Application Reference Number:	2026/0600
--------------------------------------	-----------

Application Type:	Listed Building Consent
--------------------------	-------------------------

Proposal Description:	Listed Building Consent for the subdivision and change of use of the building to provide a ground floor office and laundrette, with four studio apartments at first and second floor level, together with associated internal alterations, fire and acoustic separation works, internal bin storage, basement storage, revised access/frontage arrangements and associated works (Retrospective)
------------------------------	--

Location:	8 Regent Street, Barnsley, S70 2EJ
------------------	------------------------------------

Proposed First Floor Plan
scale 1:50

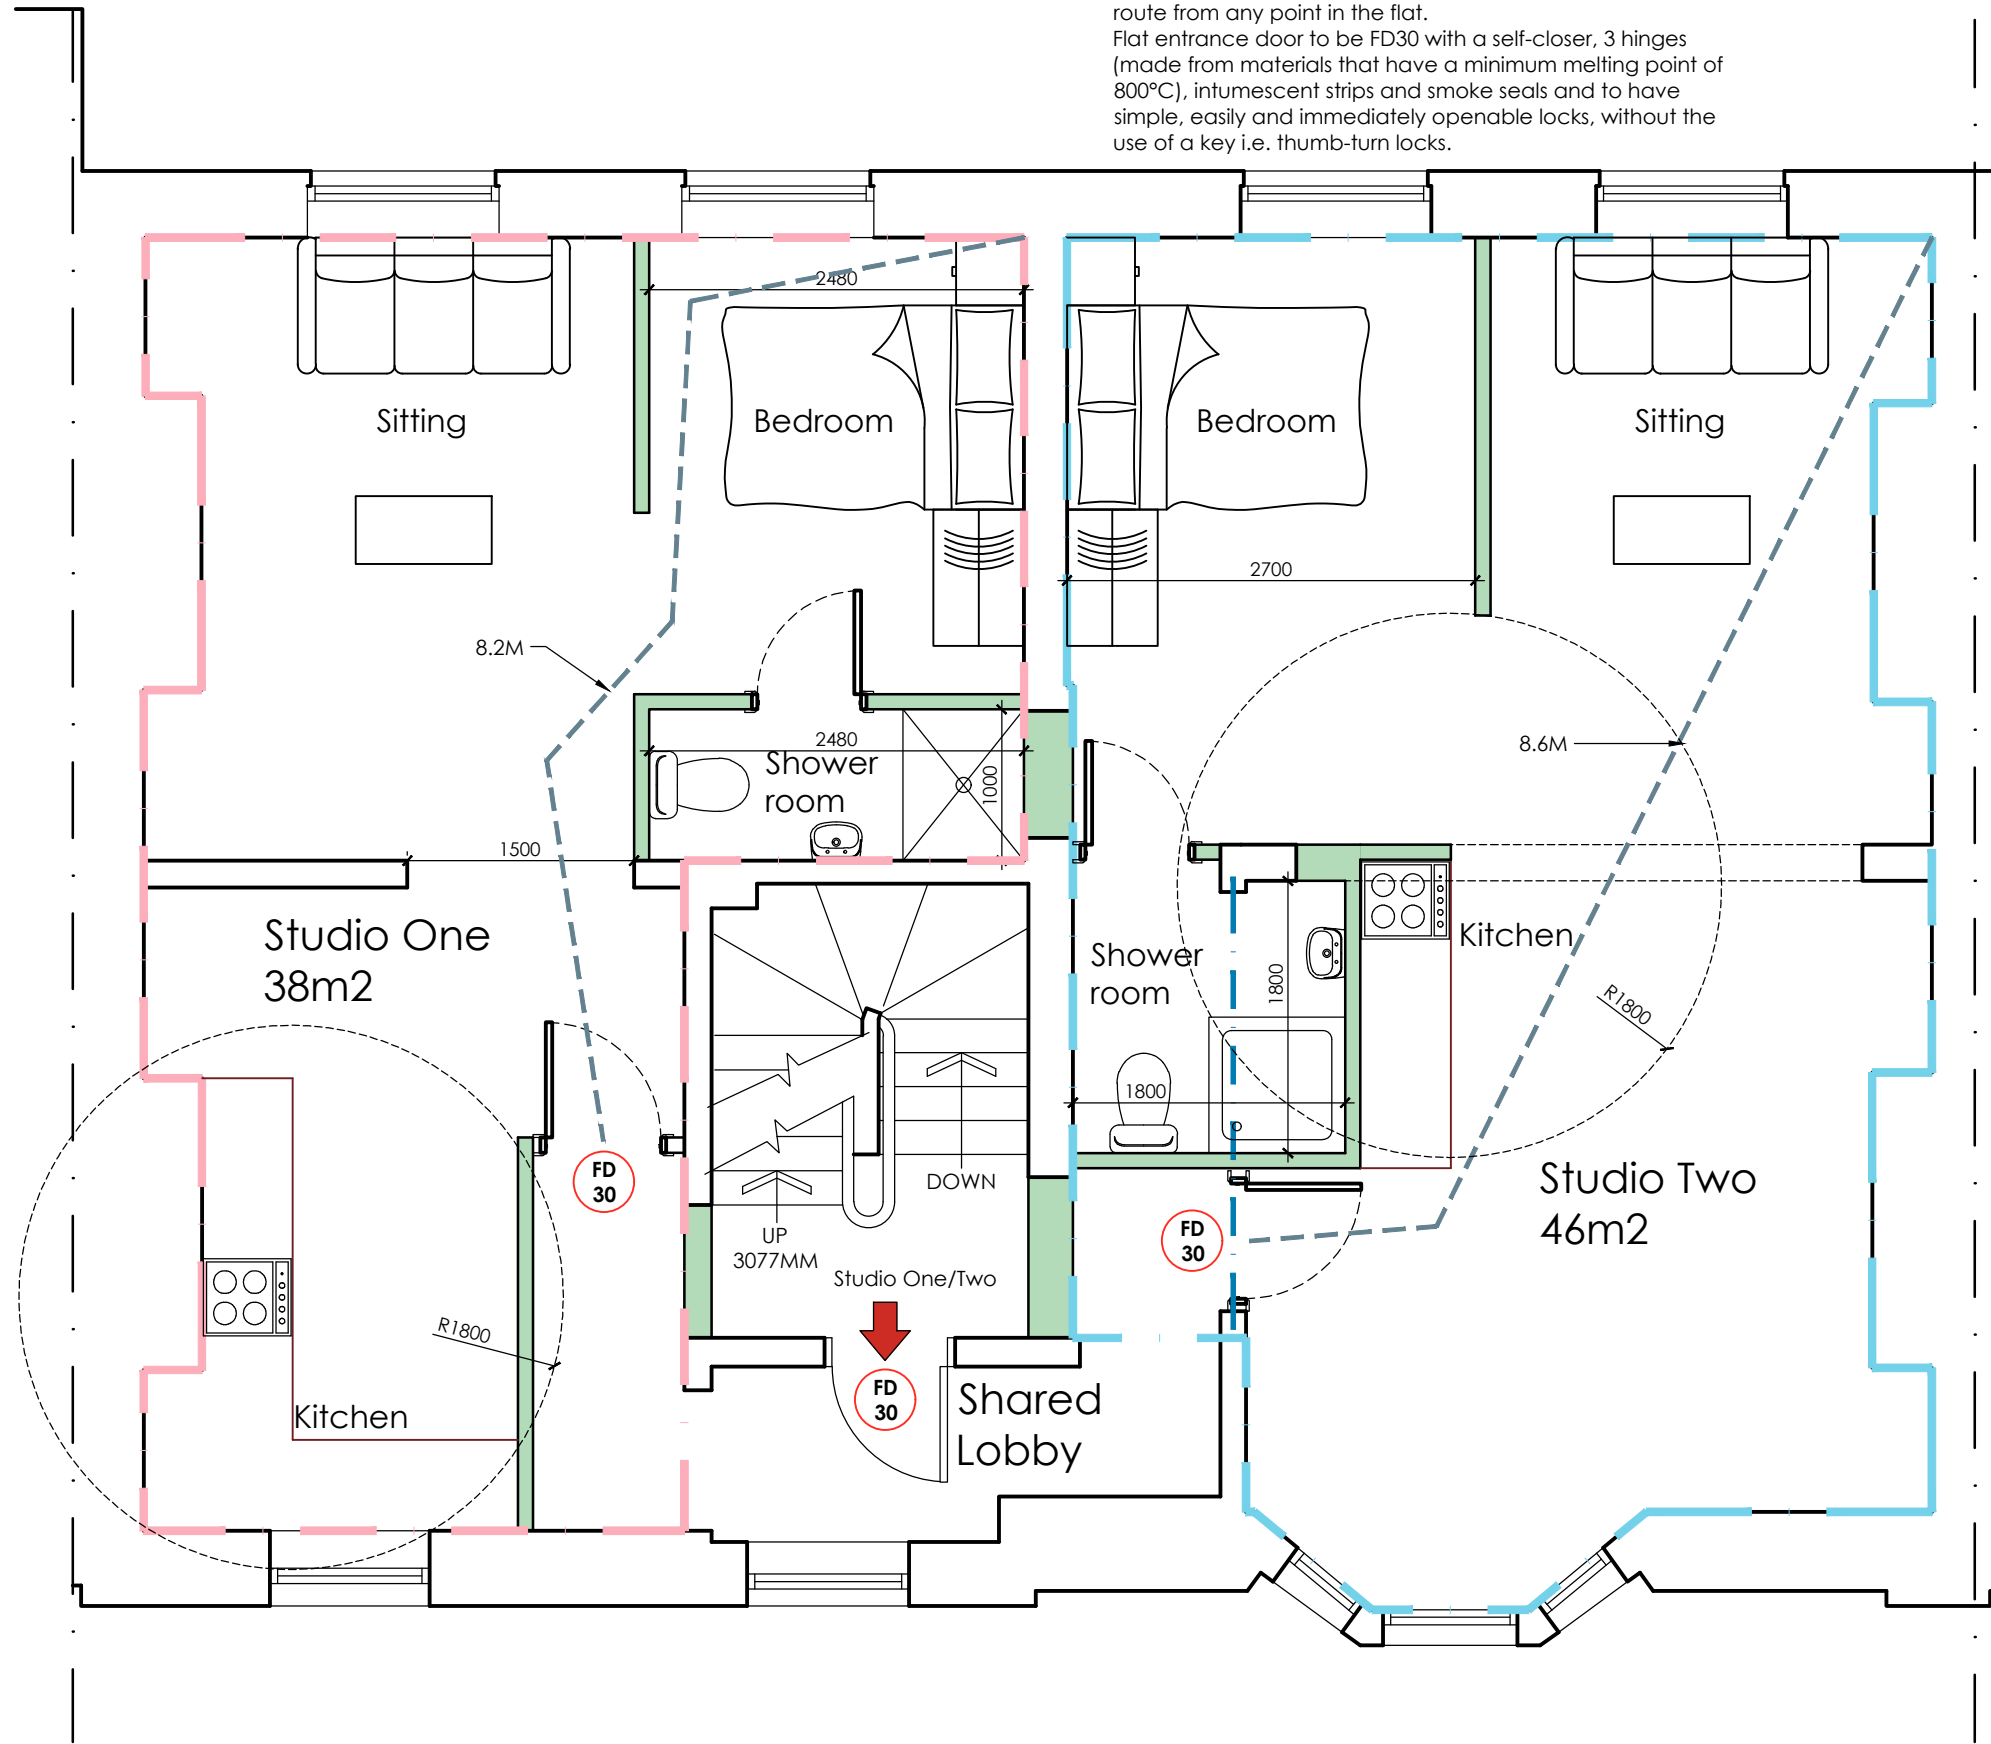
Regarding the proposed removal of the structural wall at first floor level between Studio 2 and the shared lobby. This appears to be an original structural wall, and its removal would be a more intrusive intervention. It would introduce a minor degree of harm to the historic fabric and would erode the original plan form and layout. Furthermore, regarding the proposed removal of the dividing wall between existing office rooms 5 and 6 to create the open-plan space for Studio 2. It is not clear from the information provided whether this is a stud partition, a later subdivision, or historic fabric, and this point requires clarification.
